Mayberry Filing No. 3
Traffic Technical Memorandum
PCD File No. SF2219
(LSC #S224210)
September 1, 2022

RE: Mayberry Filing No. 3
Traffic Technical Memorandum
El Paso County, CO
PCD File No. SF221
LSC #S224210

Figure 1  
**Conceptual 120' ICD  
Roundabout Parameters**

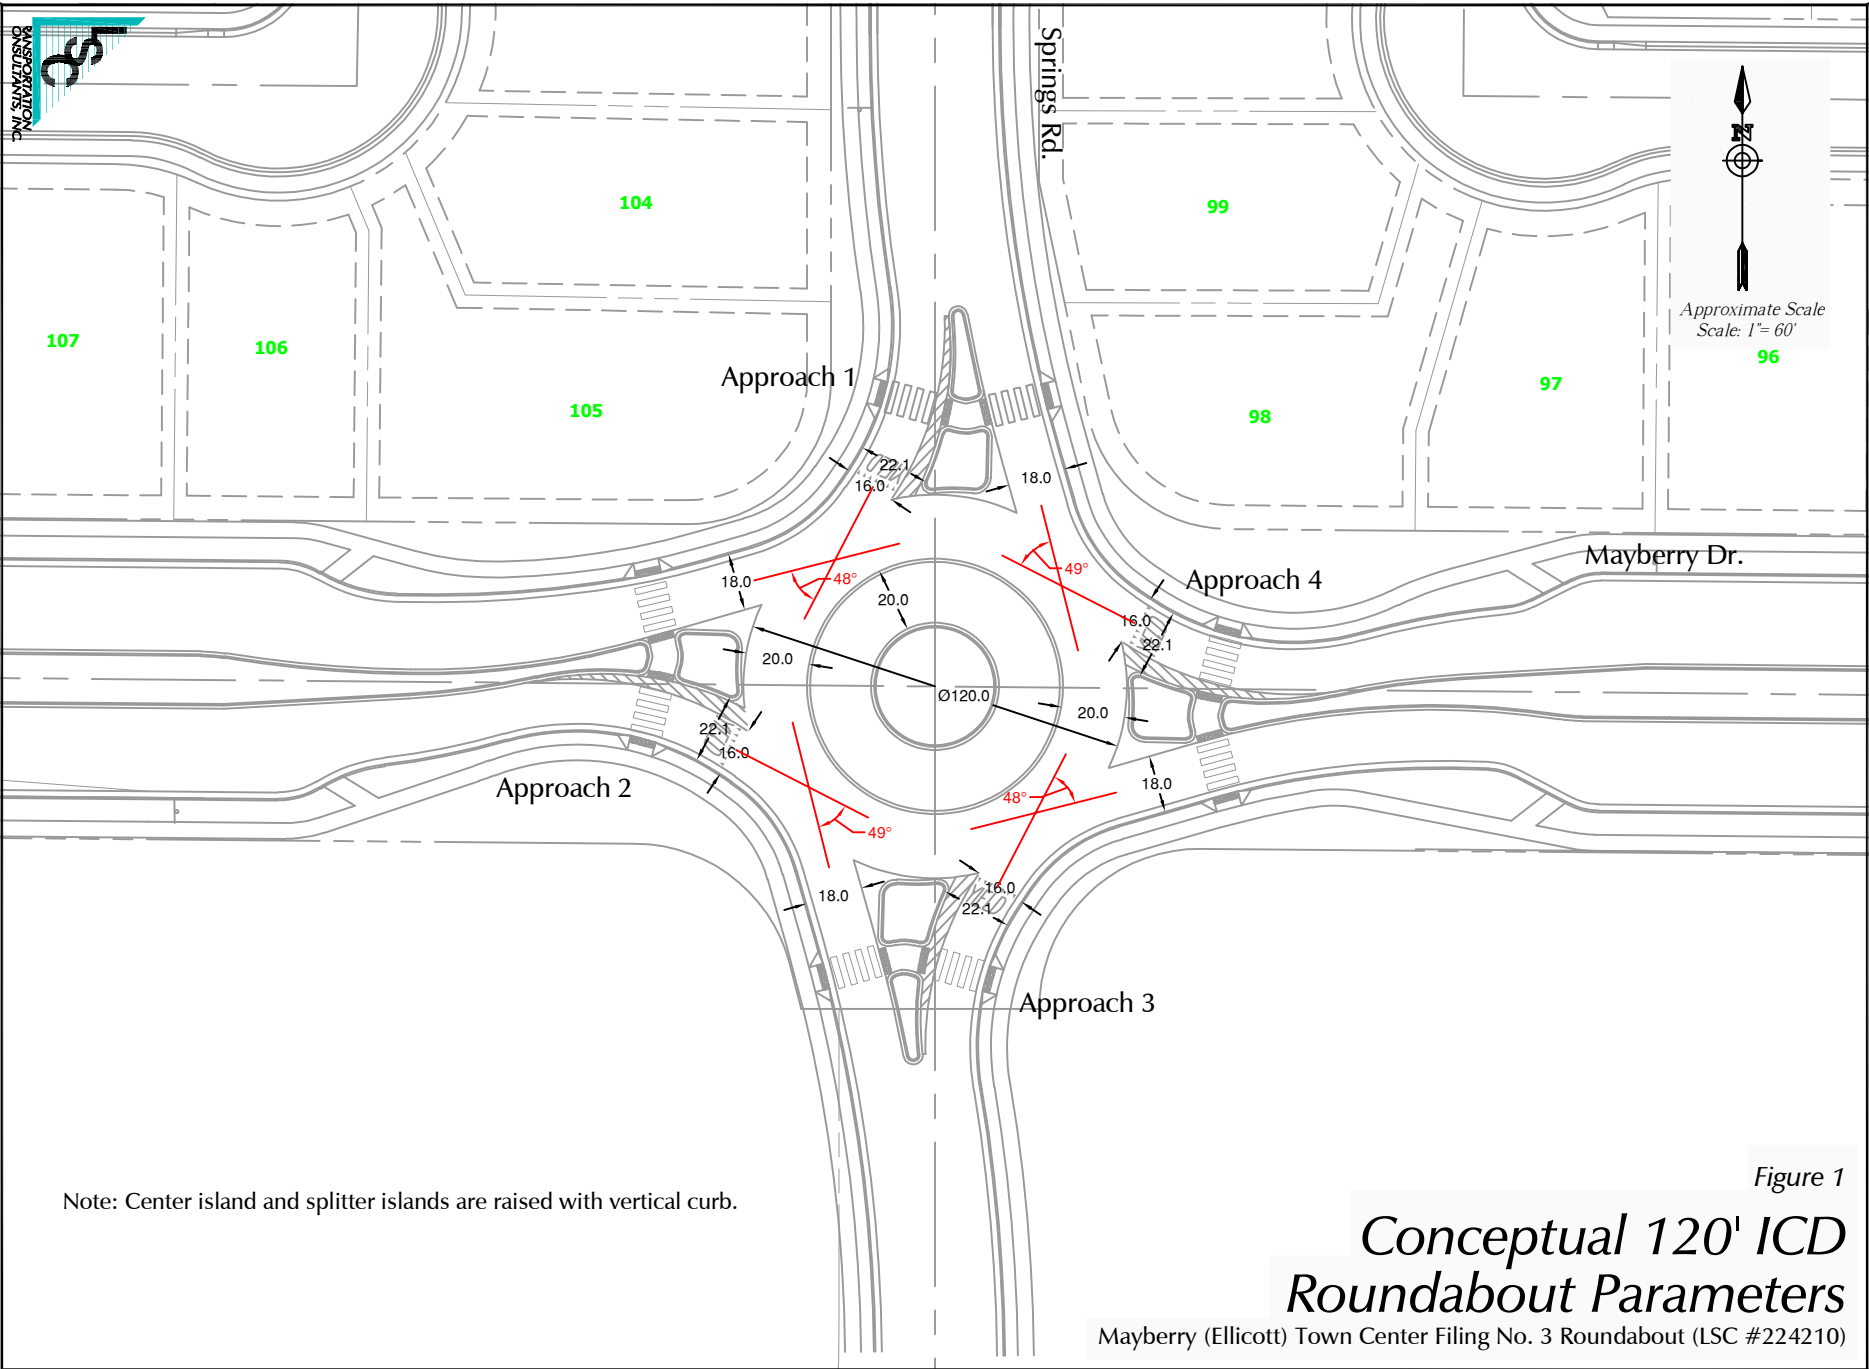
The drawing shows an entry width of 16 for each of the legs. Please clarify.

Figure 7  
*Snow Plow - Approach 2  
 AutoTurn Movement*

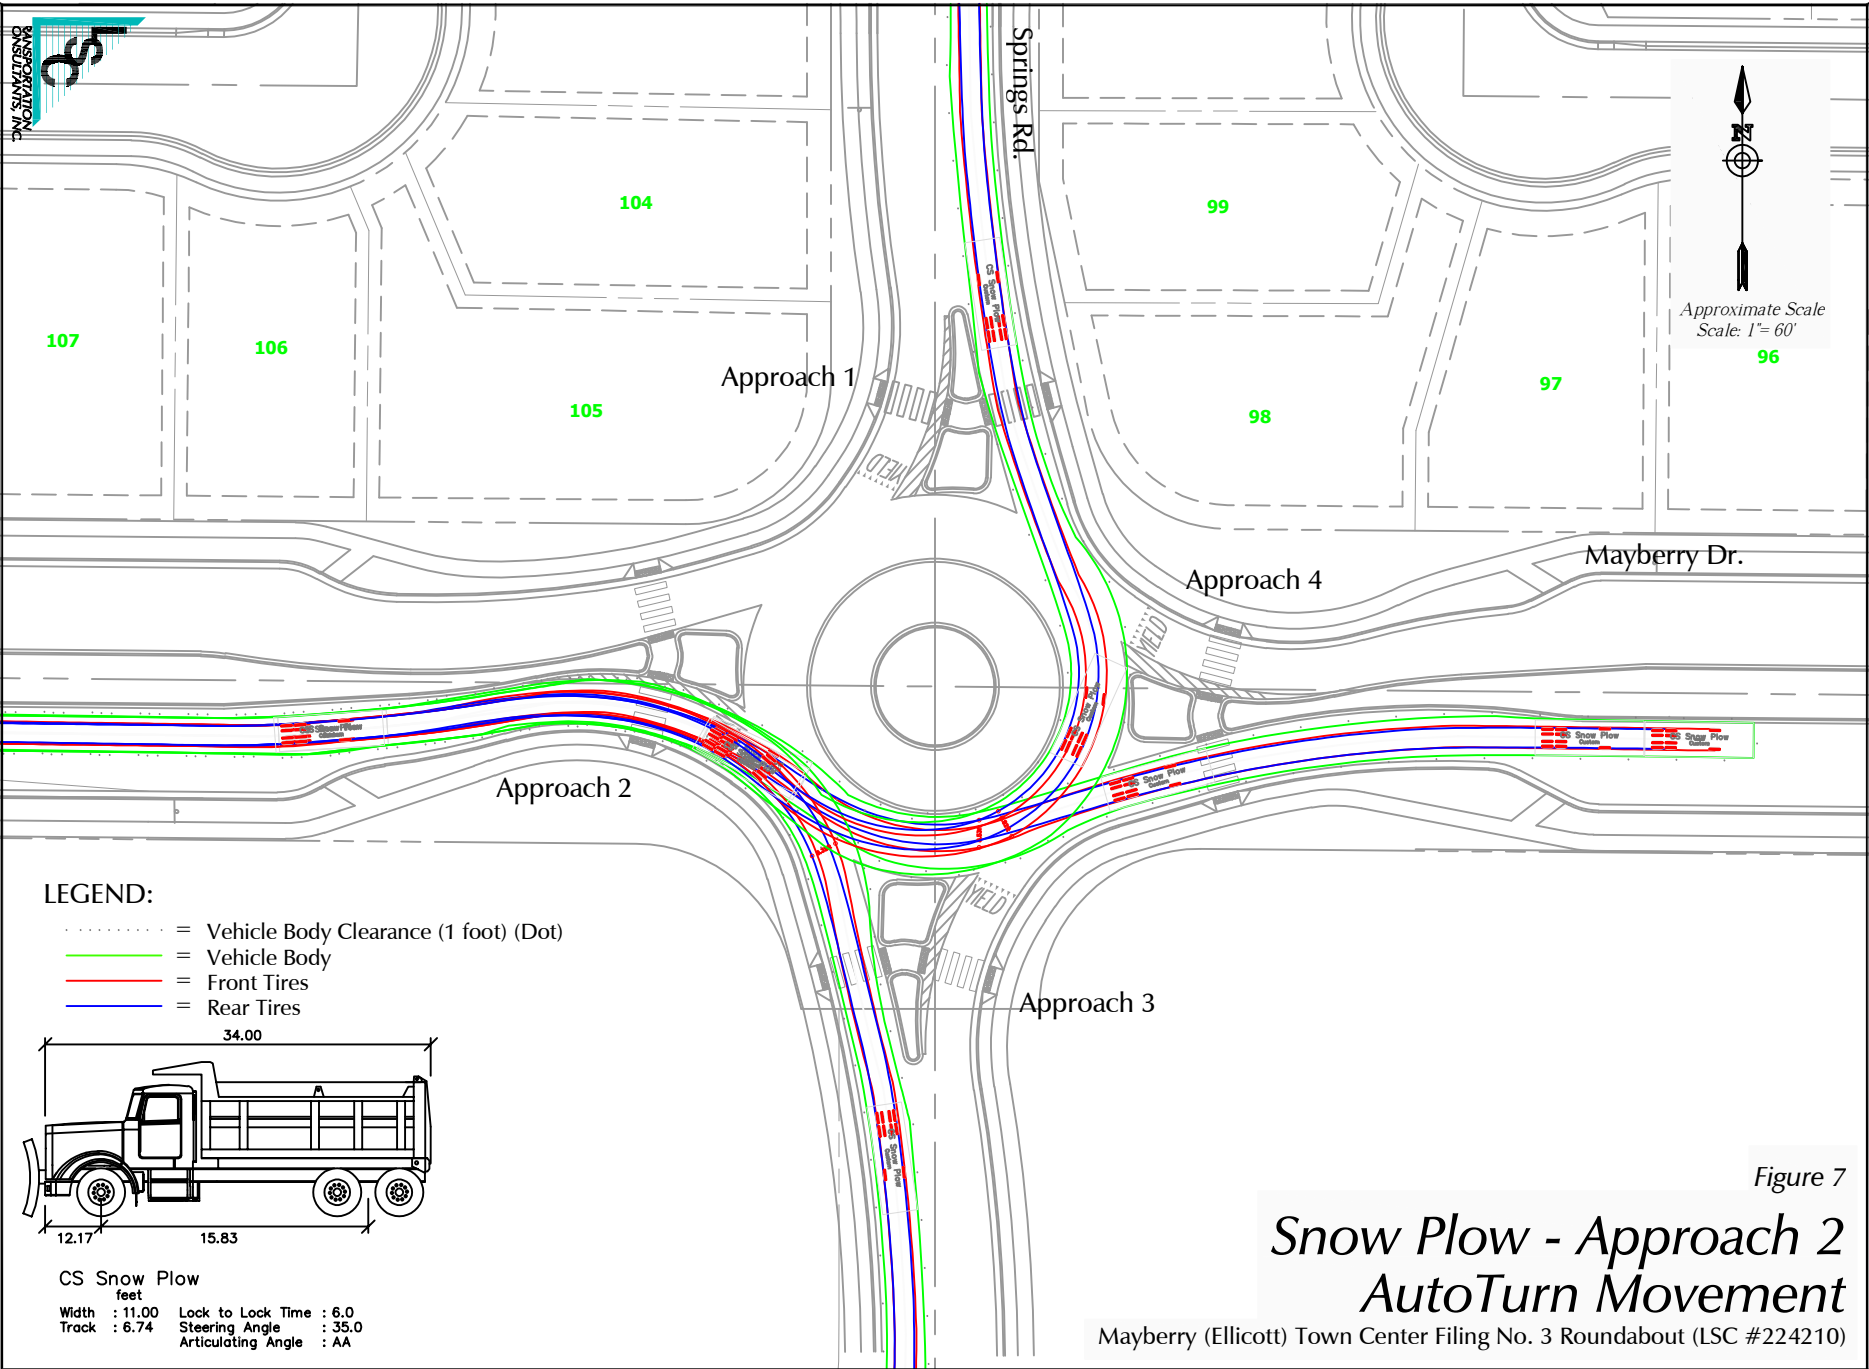
fix as the vehicle is shown to go over the curb

Figure 13

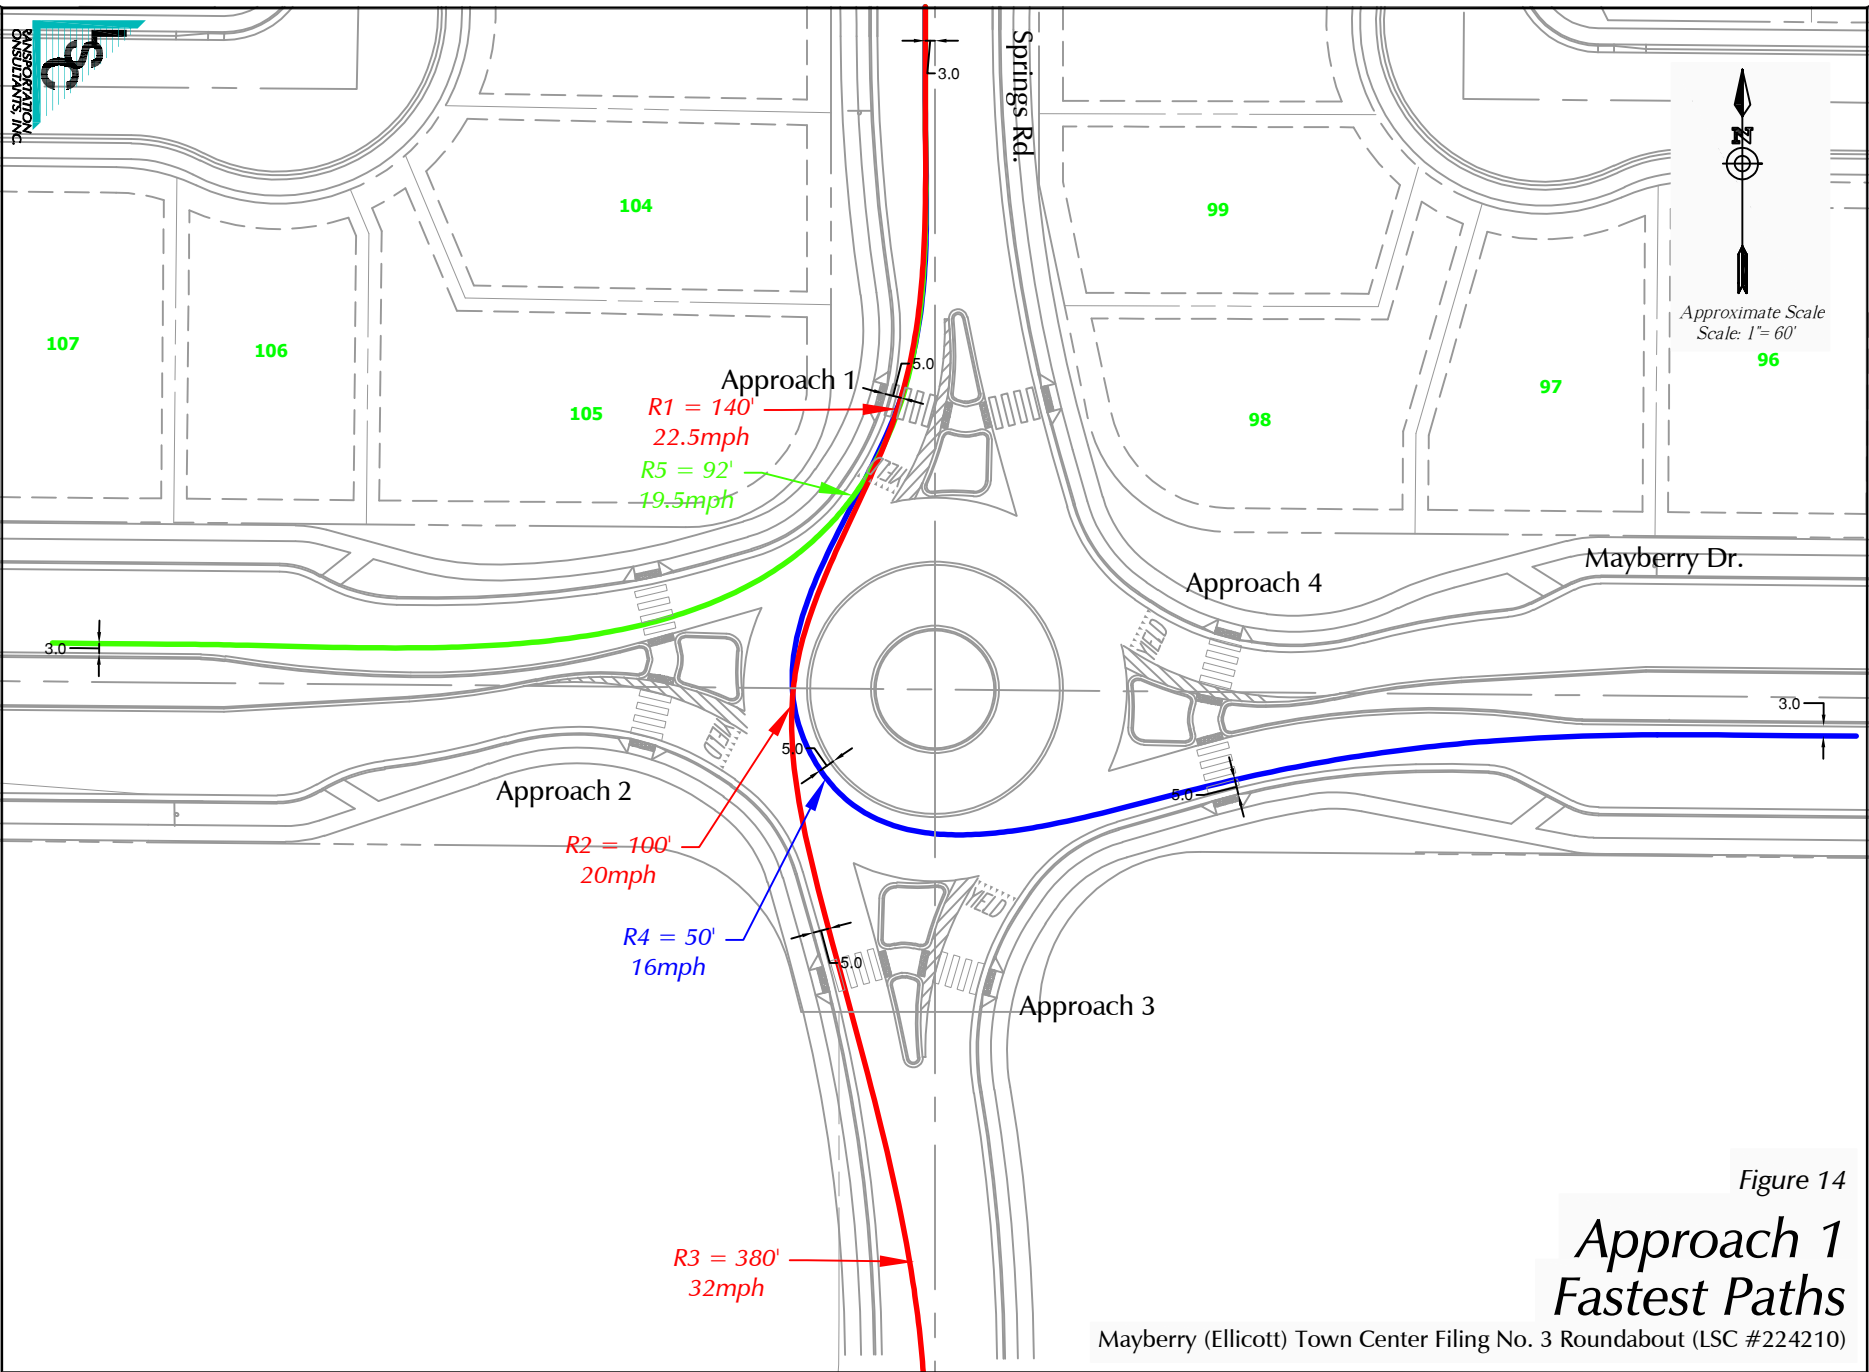
fix as the snow plow is going onto the curb
